Your ref:	Pasta Brown	<b>Please reply to:</b>	<b>Mr Joshua Wilson</b>
Our ref:	23/07815/TCH	Tel No:	
		Fee Queries:	0207 641 6500;
		Email:	planningreception@westminster.gov.uk;
Mrs Natalie Baynes 31-32 Bedford Street London WC2E 9ED United Kingdom		<b>Incomplete Applications</b> Town Planning & Building Control City of Westminster PO Box 732 Redhill, RH1 9FL	
		16 November 2023

**Address: 31 - 32 Bedford Street, London, WC2E 9ED,**

**Proposal: Use of two areas of the public highway measuring 6m x 0.75m and 4m x 0.75m for the placing of five tables and 10 chairs in connection with existing restaurant**

Designated seating area  
6.0 x 0.75 = 4.5 sq.m

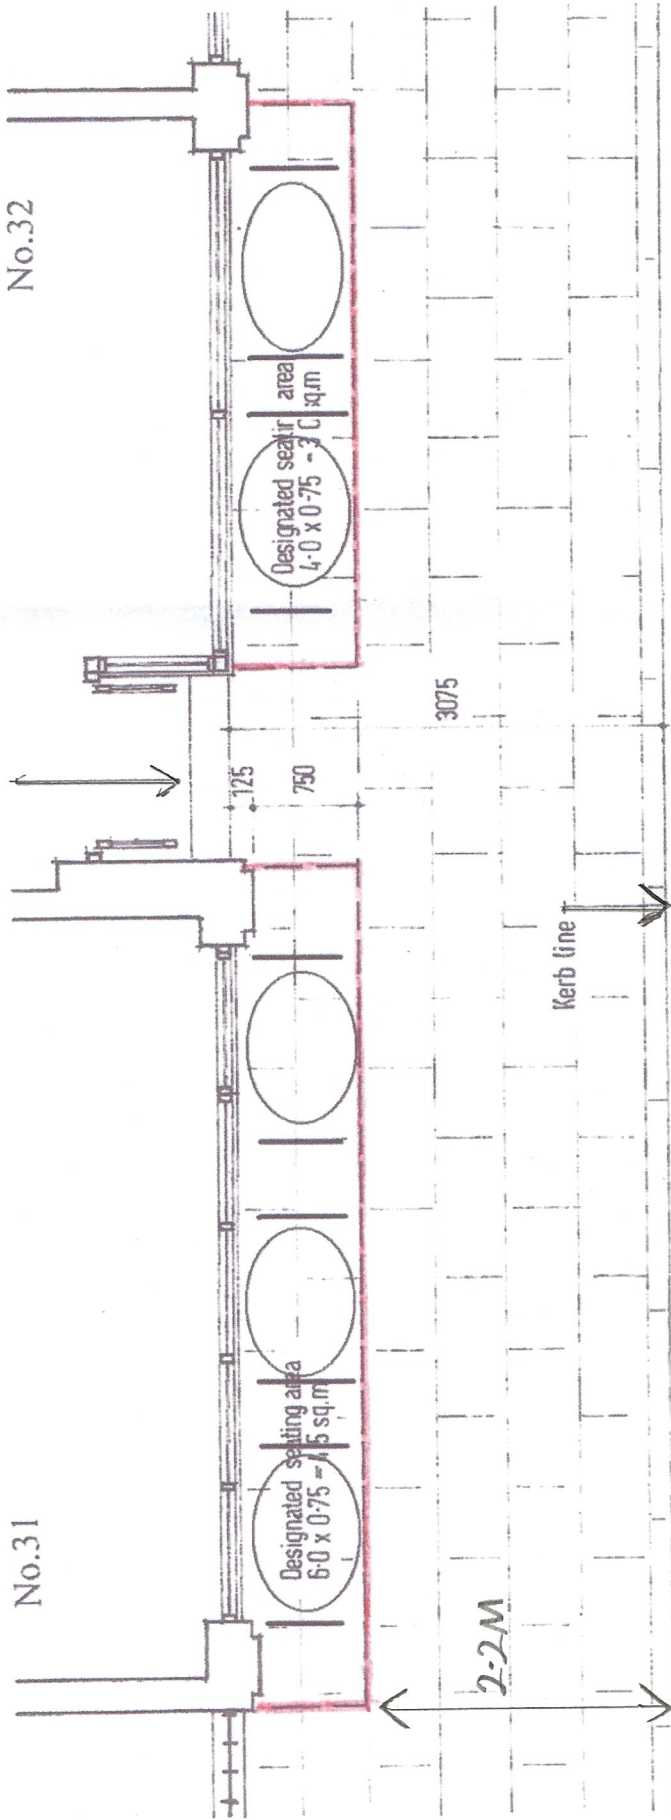
- 2 Please provide a plan at a scale of 1:50 showing the area of public highway to be used outlined in red, the proposed layout of the tables and chairs within this area, the location of the kerb and the location of the entrance to the building/restaurant. You must indicate all street furniture and street items such as lamp posts and indicate their distance from the tables and chairs area. Your plans and drawings must be accurate and drawn to a recognised metric scale, include a scale bar, with precise dimensions stated for important details such as the distance between the tables and chairs area and the kerb edge. You must give each plan a distinctive reference number.

3 Some or all of the drawings submitted with your application do not include a scale bar, please amend the drawings to ensure all drawings include a scale bar.
